Recommendation Report for Planning Permission for Works or Extension to a Dwelling

REF NO: FP/178/19/HH

LOCATION: 30 Downview Road
Felpham
PO22 8HQ

PROPOSAL: Single storey side infill extension, porch to side, first floor rear extension and extension to existing garage

DRAWING	003 Existing & Proposed FF Plan		
DATE	14 08 19		
AUTHOR	AH	REVISION	CORINTHIAN ARCHITECTURAL DESIGN 8 Davys Court, Funtington, Chichester, West Sussex. PO18 9LG 01243 576 078 > contact@corinthianad.co.uk > www.corinthianad.co.uk
STATUS	PL		
SCALE	1: 100 @ A3

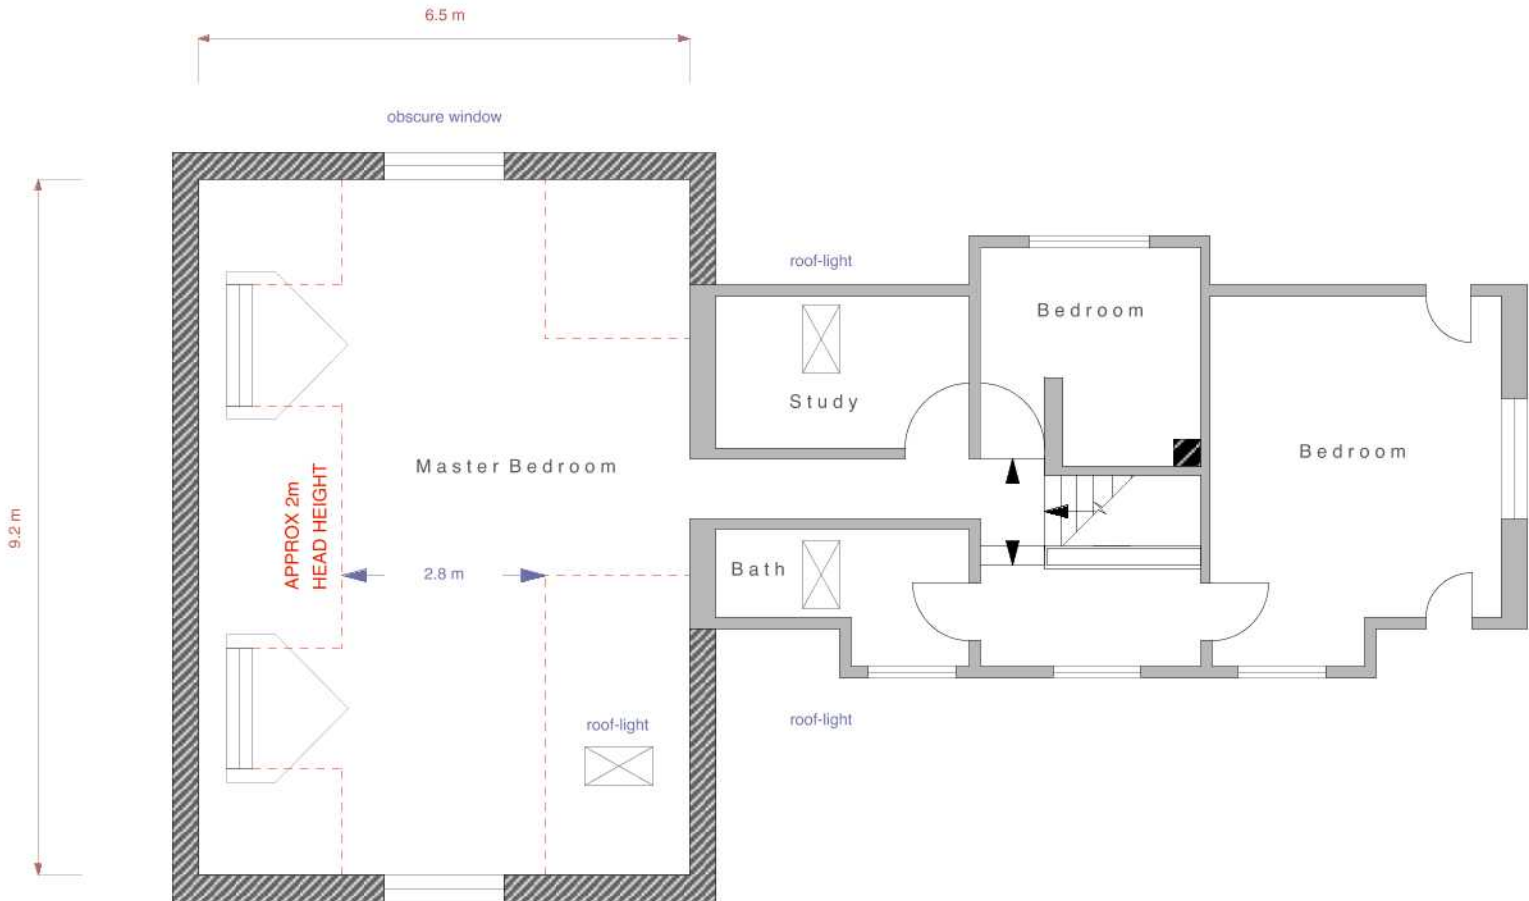
The first floor appears large however it is not considered to appear significantly overbearing as a result of the siting which is situated away from the neighbouring property at No.28. Again, due to it siting at the north, will not result in adverse overshadowing.

Additional windows and doors to the ground floor are not considered to result in adverse overlooking due to them being single storey in height and with sufficient boundary treatment in place. The plan shows the first floor window to the south is to be obscured. As the window faces directly south over the neighbouring property rear garden and rear elevation, it is likely to give rise adverse overlooking and as a result it will be conditioned to remain obscured glazed. The first floor window to the north will have views over the street scene.

- 4 The first floor window to the southern elevation of the extension shall at all times be glazed with glazed with obscured glass and only openable at a height level at least 1.7m above finished floor level.

DRAWING	005 Proposed Elevations	
DATE	14 08 19	
AUTHOR	AH	
STATUS	PRE-PL	
SCALE	1: 100 @ A3	
REVISION		
CORINTHIAN ARCHITECTURAL DESIGN		
8 Davys Court, Funtington, Chichester, West Sussex. PO18 9LG		
01243 576 078 > contact@corinthianad.co.uk > www.corinthianad.co.uk

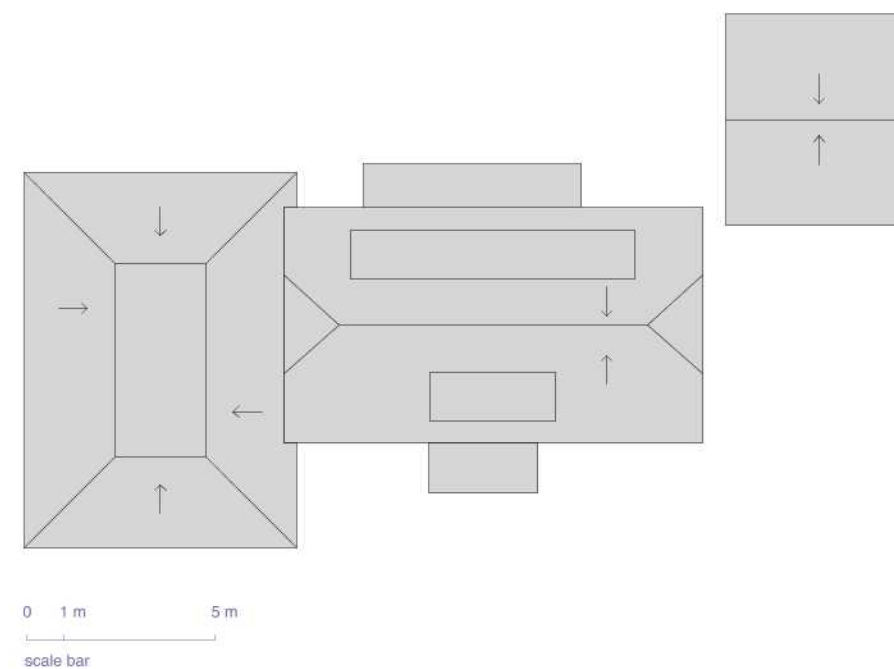
The extension to the garage will have a depth of 3.5m and a height of approximately 4m with eaves to 2m. Whilst it is sited closed to the boundary, the neighbouring property has a catslide roof to the northern side and as a result with the low level eaves height the garage extension is not considered to result in adverse impacts. The porch alterations are also minor and are not considered to result in adverse impacts upon amenity.

2 dormers are proposed to the rear. These are modest in size and are considered to sit comfortably within the roof slope. They have a depth of 1.15m and a height of 2.5m. There is 18m retained to the rear elevation which is considered sufficient to ensure there is no adverse overlooking. No.4 'George IV Walk' is situated to the rear however with no side windows to the first floor, the addition is not considered to result in adverse overlooking.

Proposed North Elevation 1:100 scale

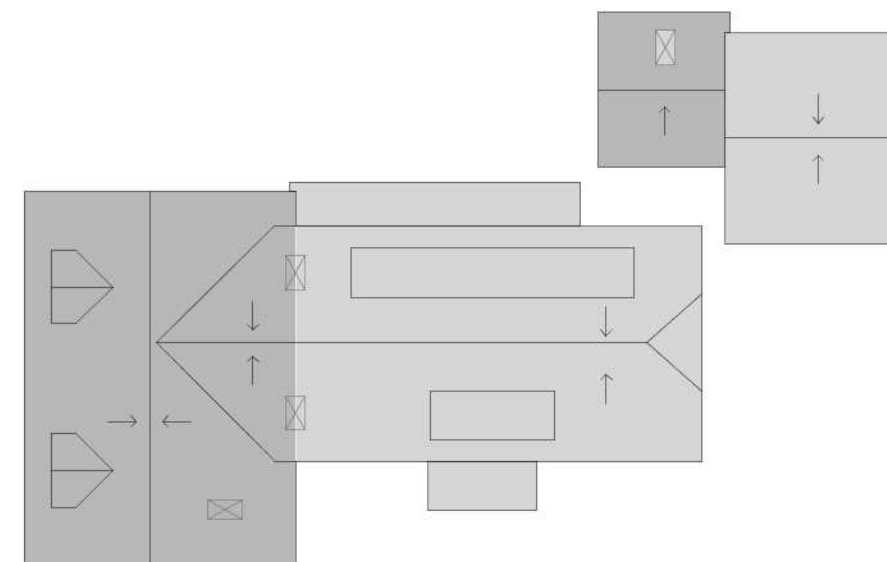
Due to the siting of the property, the increase in height to the rear would appear dominant upon the street scene with 'George IV Walk' running alongside the dwelling to the north, however the increase is not considered to result in a significant impact in which a refusal is justified. This is as a result of the development extending along a short section of approximately 7m along the northern elevation, 1m is also retained to the boundary. The first floor extension will have gable ends and as a result of the increase in scale, it would alter the appearance of the dwelling when viewed from the front and side elevation. However, the materials proposed for the development would match that of the existing dwelling which helps to ensure it appears well integrated. The development is also not considered to appear as an overdevelopment on the site.

007 Location Plan at 1:1250 scale

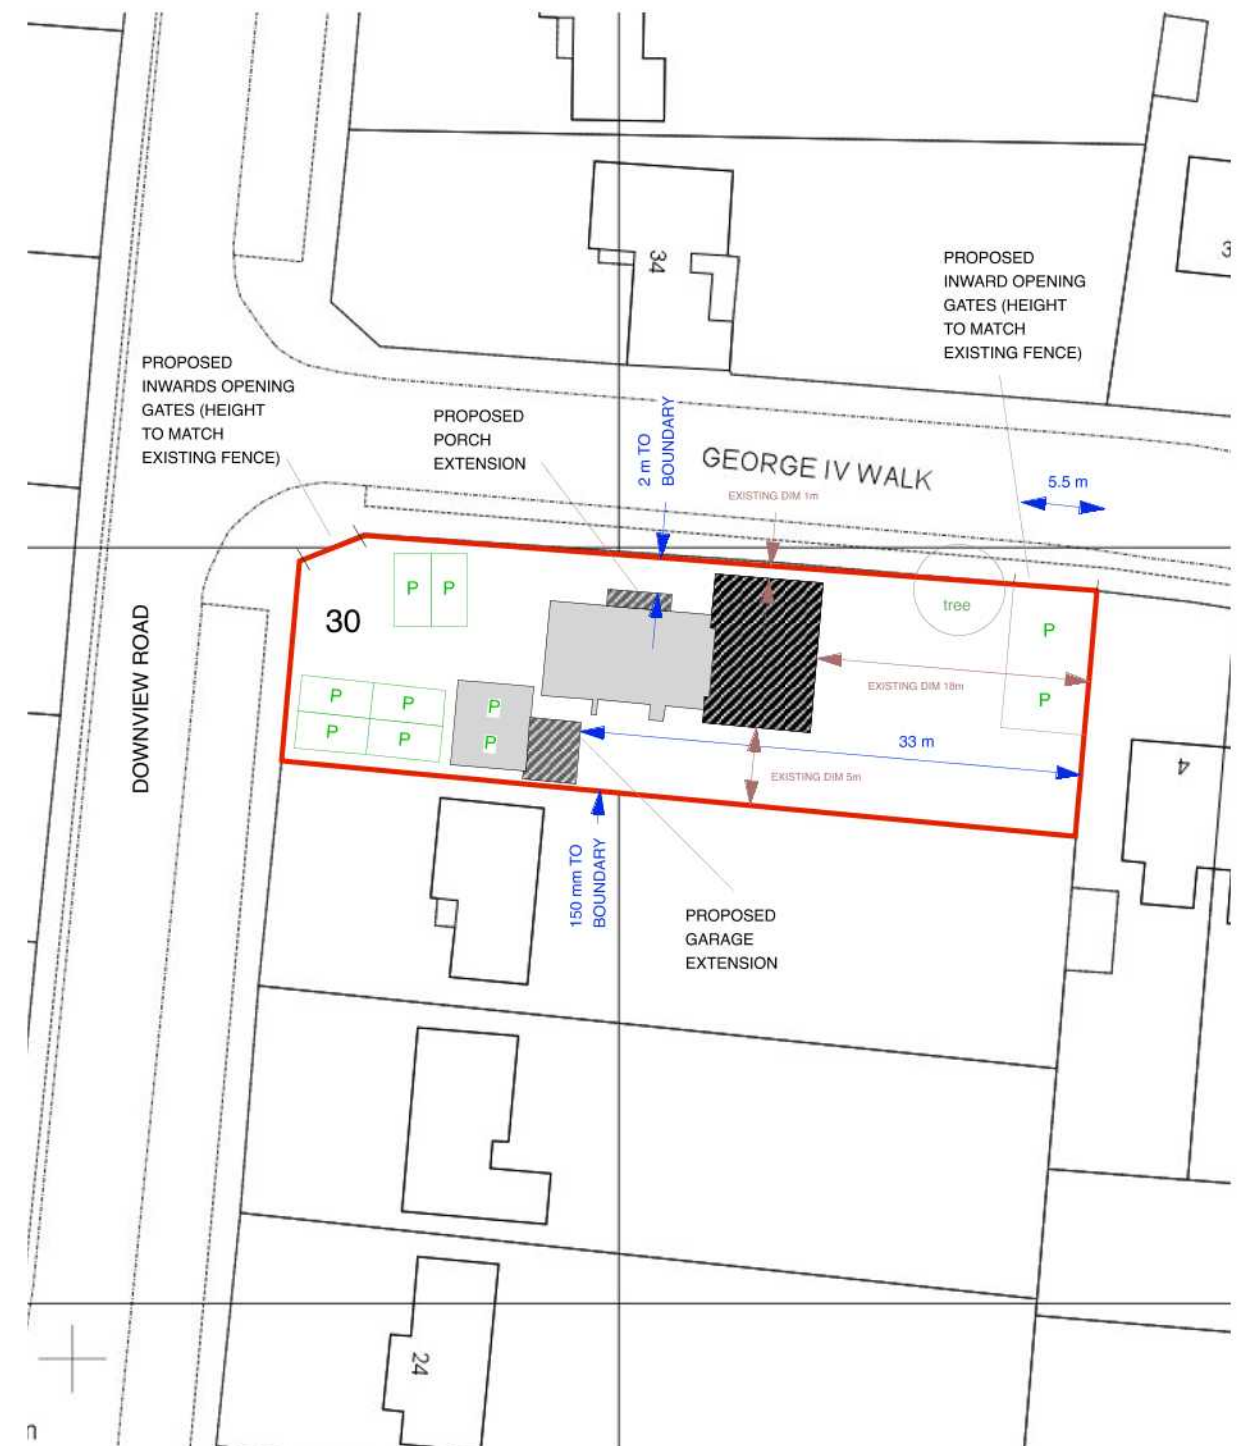
- The plans show 8 parking spaces, these could not be utilised at any 1 time and needs clarification.
- The use of tarmac is non permeable material and contrary to the Felpham Design Guide.

Comments noted. Materials proposed for the parking will be permeable as shown on the approved plan.

A new driveway will be created to a section of the rear garden. This will be of porous hard surface as shown on the plan submitted. It is not considered that the installation of gates will adversely impact upon the appearance of the street scene or give rise to highway issues as it creates additional off road parking spaces.

Proposed North Elevation 1:200 scale

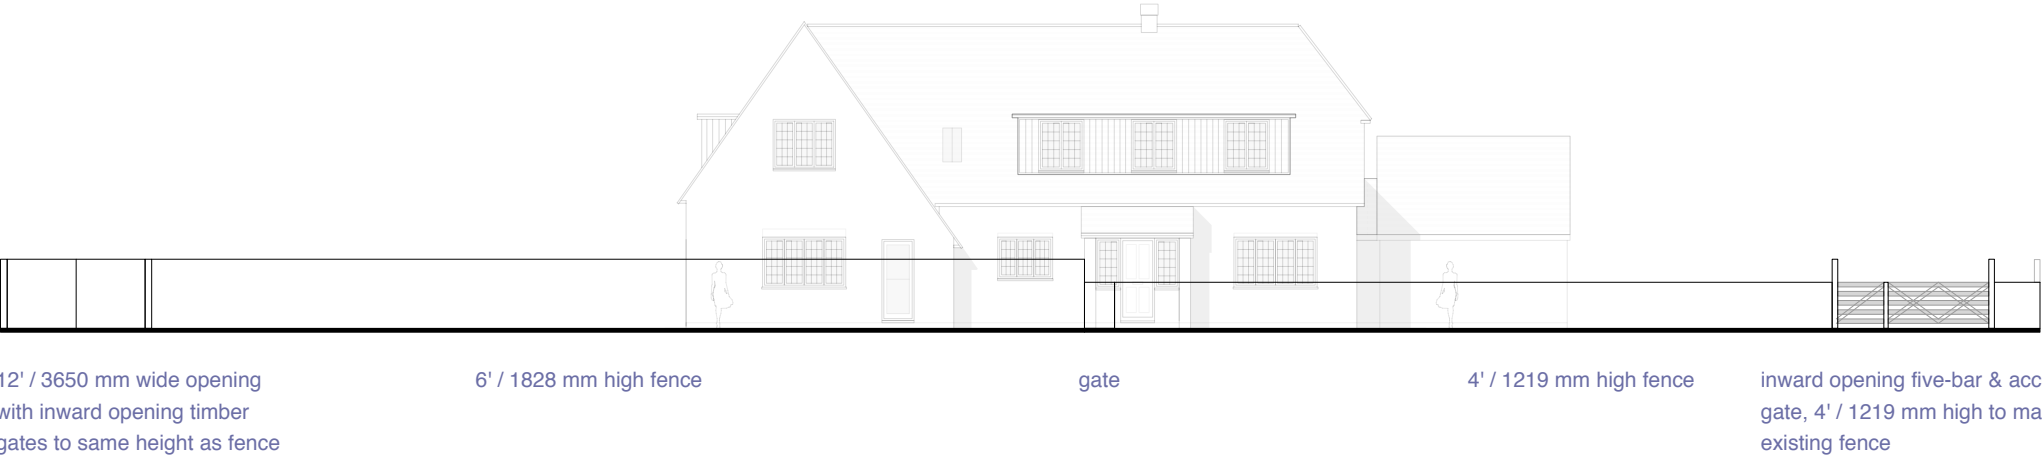
The proposal also seeks to alter the parking to the property. The site currently has fencing running along the western and northern boundary. There is currently driveway access to the north western corner of the site. This access will remain as existing at a width of 3.73m however wooden gates will be constructed. These will not exceed the height of the existing fence panels at 1.2m.

To the north eastern corner of the site, a new access is proposed. This will remove existing fence panels with the width not exceeding 3.6m. Gates will then be constructed to open inwards and to a height of 1.8m to match that of adjacent fence panels. No comments have been received from WSCC Highways however an informative will be included regarding a permit which will be required for a vehicular crossover.

- 5 INFORMATIVE: The applicant is advised that in addition to obtaining planning permission that they must also obtain formal approval from the highway authority to carry out the site access works on the public highway. The granting of planning permission does not guarantee that a vehicle crossover licence shall be granted.
